# Officers Report

Tel: 01895250320  
Case Officer: Maria Tomalova  
Email: mtomalova@hillingsdon.gov.uk  
Date: 25th January 2018

RE: Double storey side extension and conversion into 2 self contained units.

SITE: 97 North Hyde Road Hayes

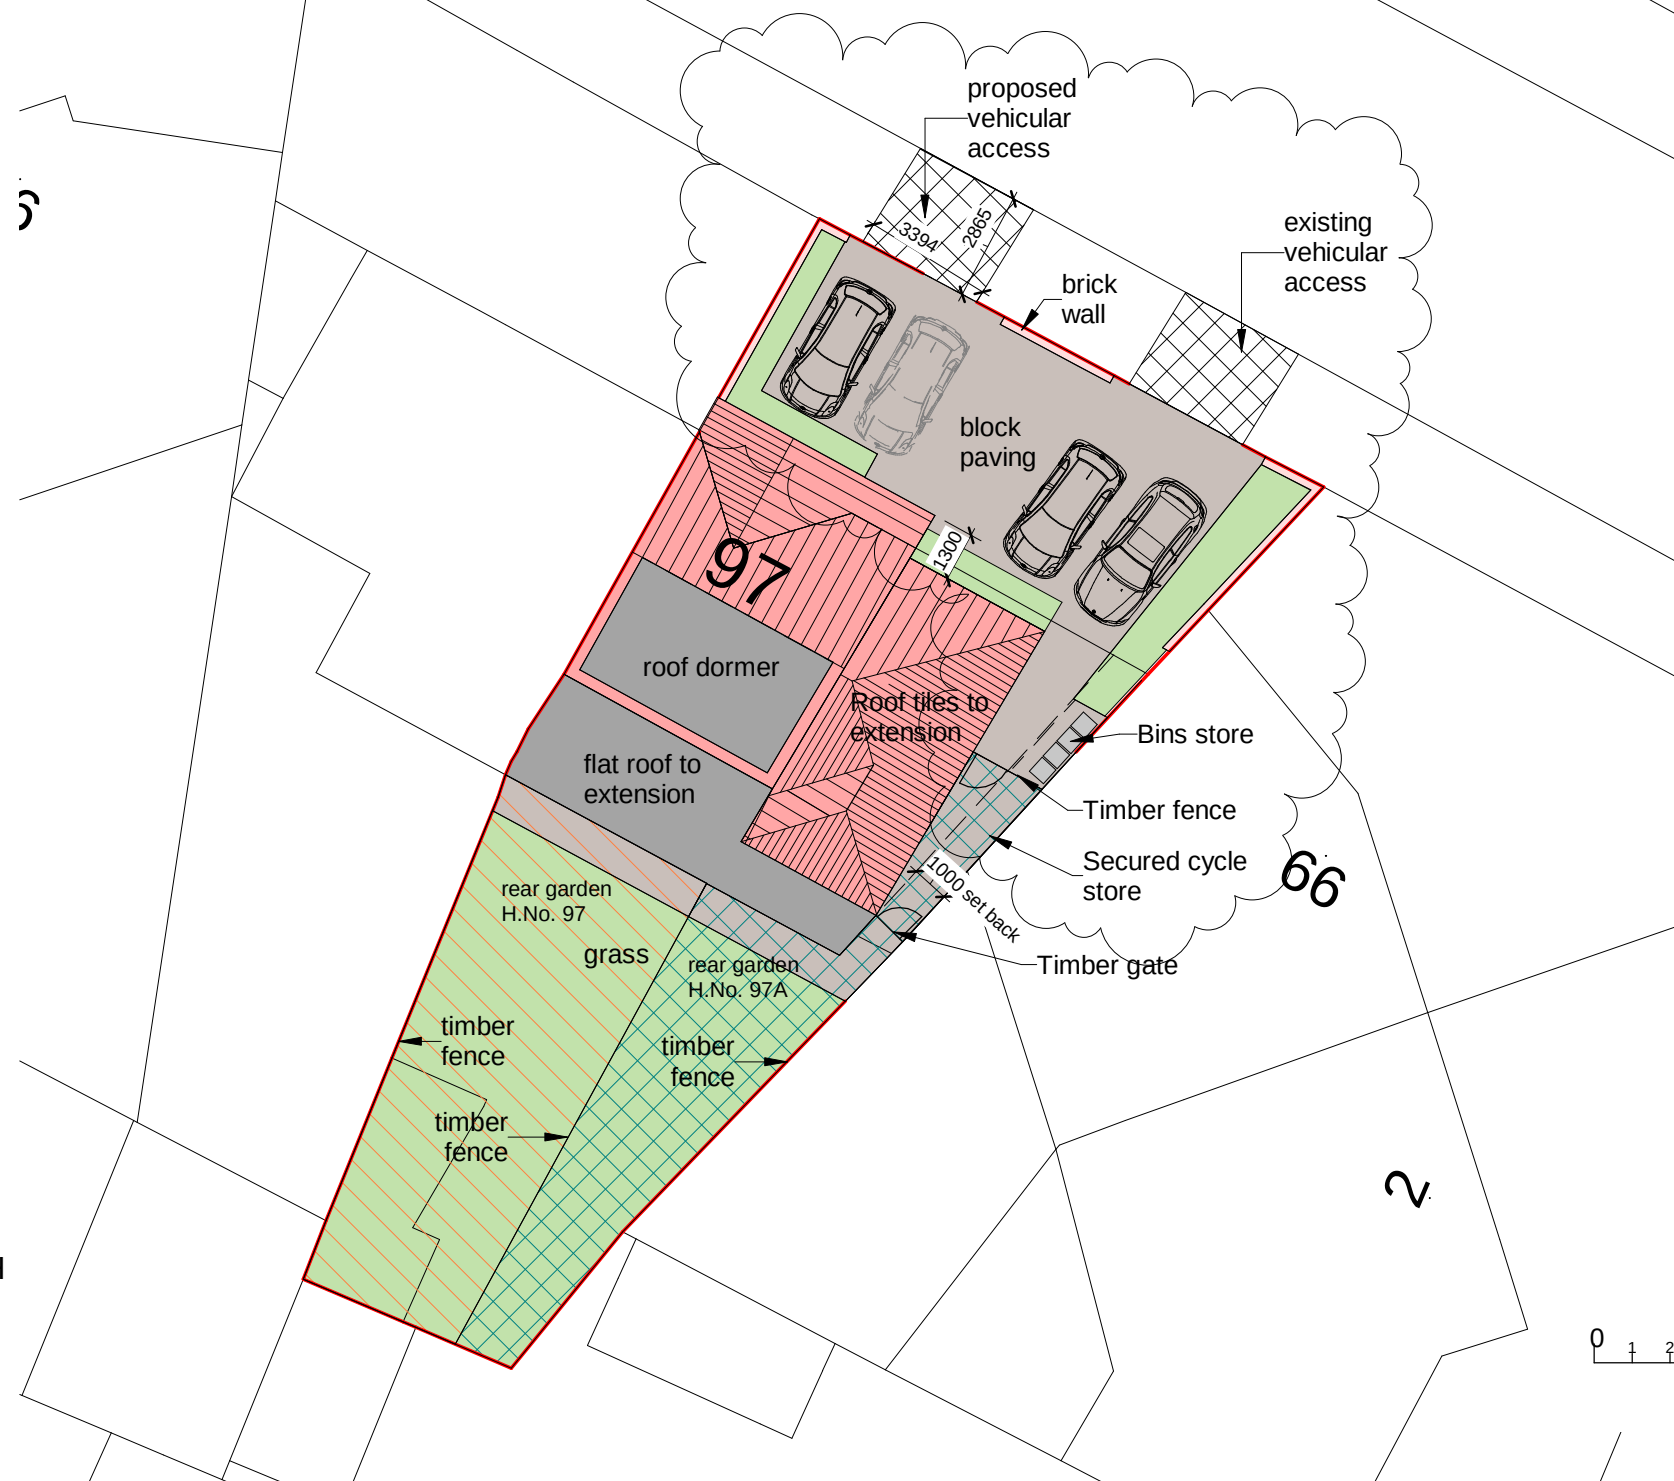
In terms of the garden area at least 55 sq.m of rear private garden should be provided to give adequate amenity space for 2 and 3 bed flats. The resultant amenity space would be approximately 100 sq.m which would be in excess of the paragraph 4.17 HDAS SPD (Residential Layout) requirement. The proposal would be in accordance with Policy BE23 of the Hillingdon Local Plan Part 2.

Policy AM14 states that new development will only be permitted where it is in accordance with the Council's adopted Car Parking Standards. These require a provision of four off-street parking spaces for two and three bed flats. The submitted drawings show the provision of four parking spaces, it is therefore considered the proposal would not result in demand for on street parking and would be in accordance with Policy AM14 of the Hillingdon Local Plan: Part Two Saved UDP Policies (November 2012). However, the arrangement of the parking area should be amended so that the parked cars would not approach the highway reversing due to the importance of North Hyde Road.

appropriate. No trees or landscaping features would be affected by the proposal. Should the applicant pursue a formal application it is recommended that landscaping details be submitted and a minimum of 25% soft landscaping provided within the front garden of the property, as required by the Councils HDAS standards.

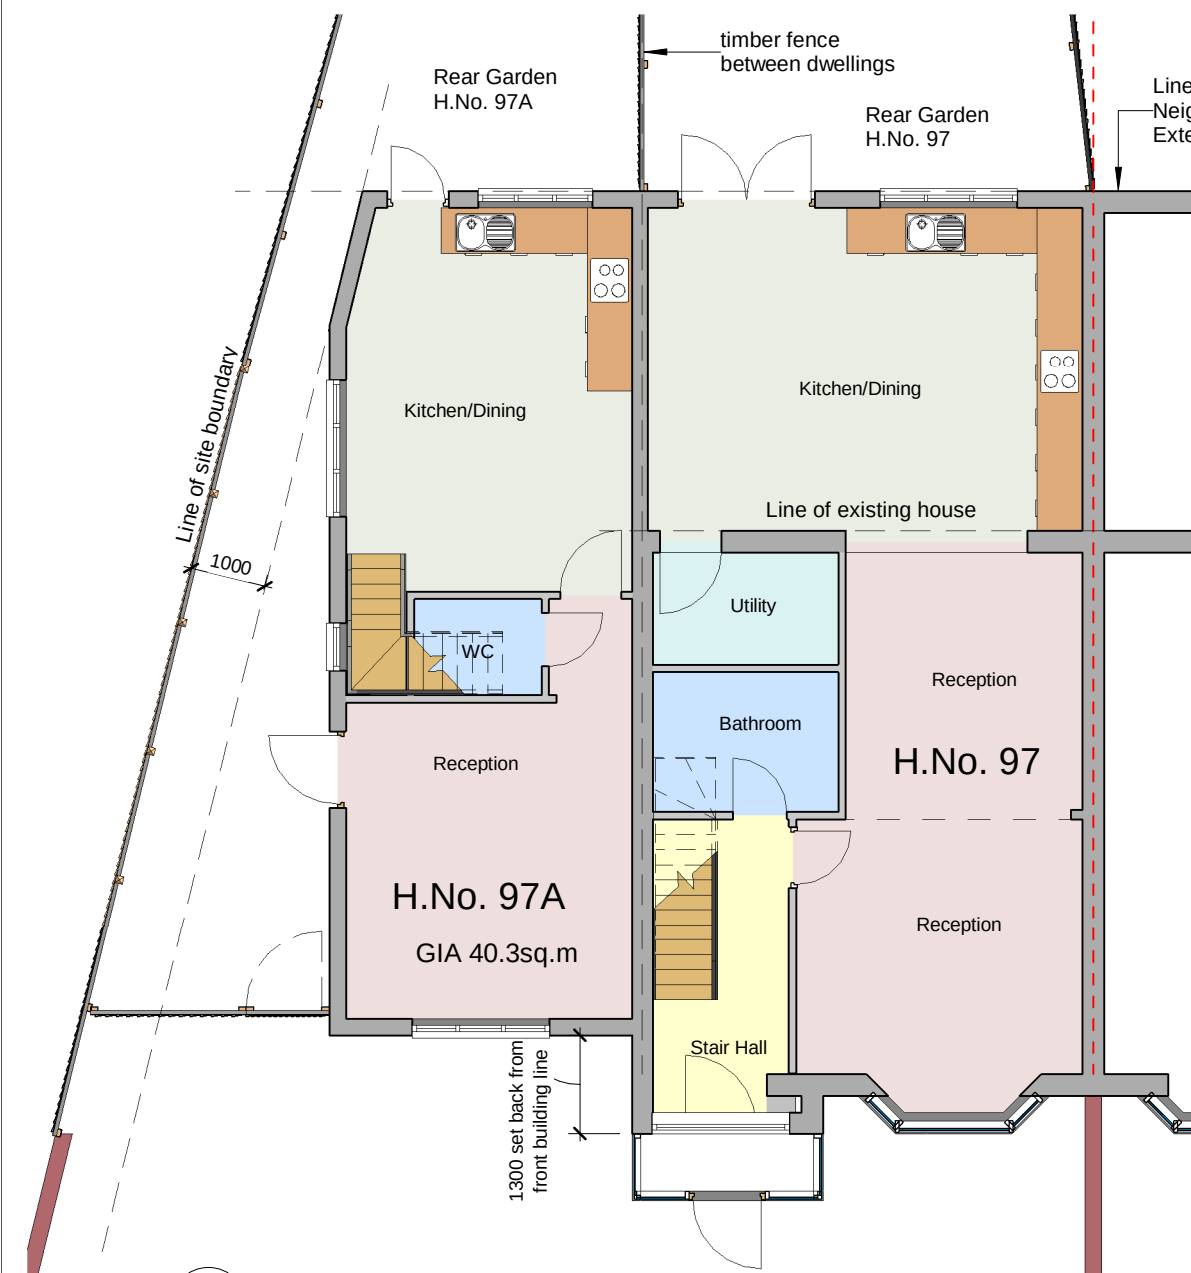
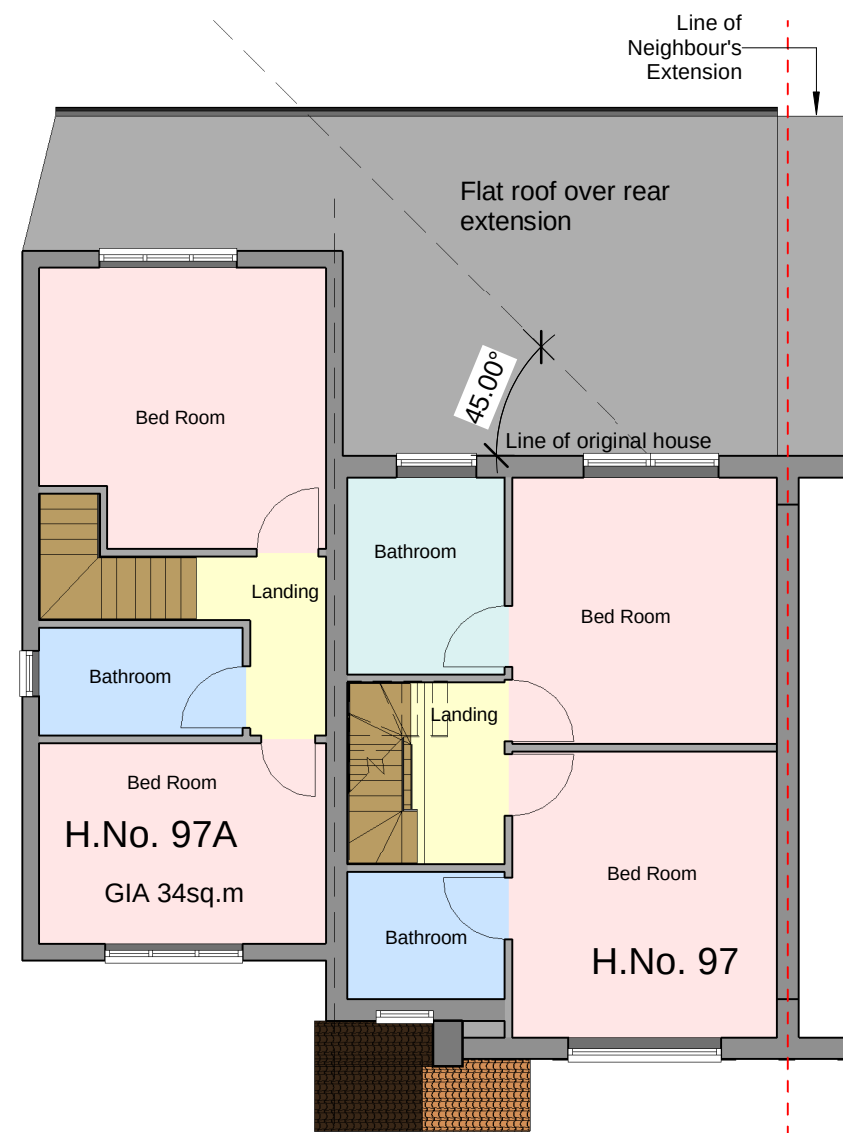
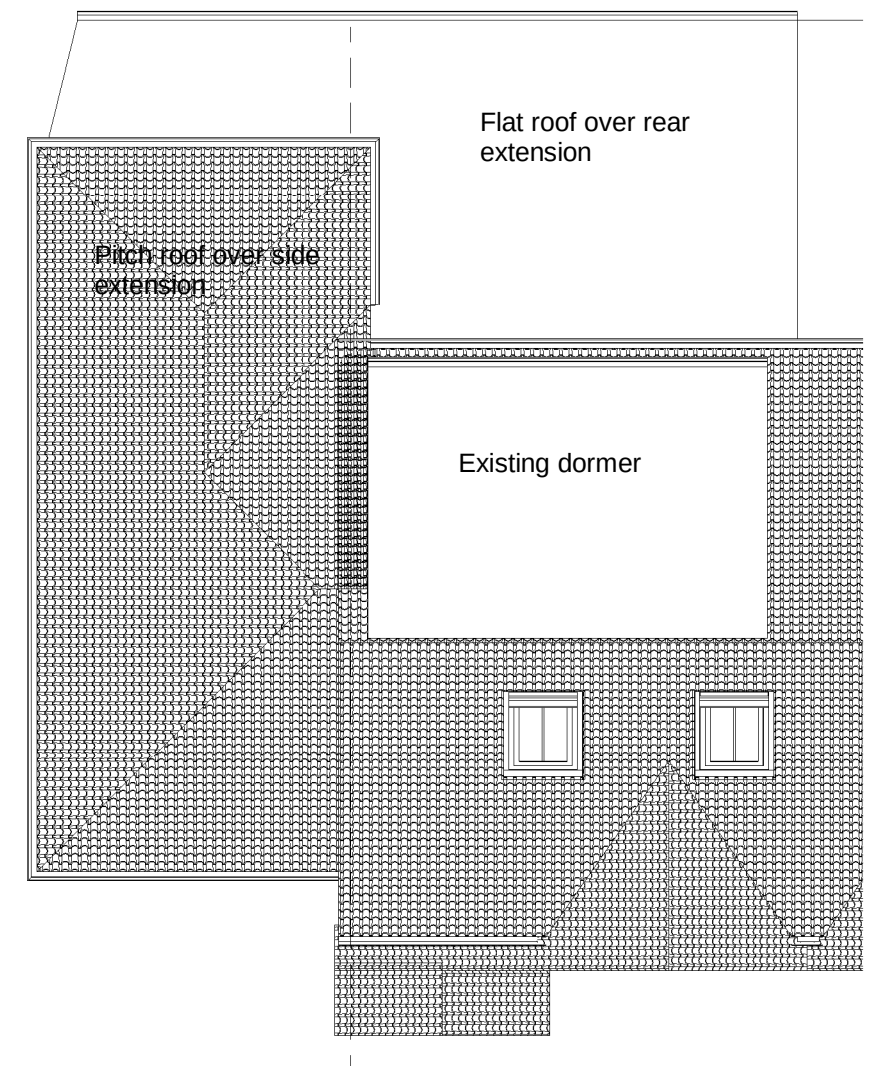
The proposed two storey side extension would replace an existing large garage of an irregular shape, would be set back 1 m from the principal elevation at both levels. The proposal would measure 4 m in width at both levels, would extend the full depth of the existing dwelling across the flank elevation and would project from the rear elevation of the original house by 3.4 m at the ground floor level and 2.7 m at the first floor level.

The proposed first floor rear extension would have a flat roof above, which is not acceptable. As mentioned above, any two storey extension to a house with a pitched roof should also have a pitched roof and a flat roofed extension will not generally be accepted. Therefore, the proposed first floor rear extension with a flat roof above due to the existing large rear dormer and those two extensions would not complement each other but on the contrary would result in a poor design, and are therefore not acceptable as mentioned in section 6.0 of the HDAS SPD. The proposed first floor extension therefore would impact unduly on the character and appearance of the existing and adjoining properties and the visual amenities of the area in general.

One large window and entrance door would be inserted on the front elevation at ground level and one window at the first floor level. The same fenestration is proposed at the rear elevation of the proposed side extension. One larger casement window and one small high level window would be inserted on the side elevation at the ground floor level and one small, non openable up to 1.7 m at the first floor level. It is considered that proposed entrance door at the front elevation of the proposed side extension should be removed and replaced on the side elevation facing to No 99 North Hyde Road.

The window inserted to the first floor side elevation would serve a bathroom.

The window inserted to the first floor rear elevation to serve a bedroom would face towards the rear garden and rear/side elevations of the neighbouring outbuildings as such no overlooking would be involved. The first floor window on the side elevation should be obscured glazed to at least scale 4 on the Pilkington scale and be non opening below 1.7 m above finished floor level (bathroom window).
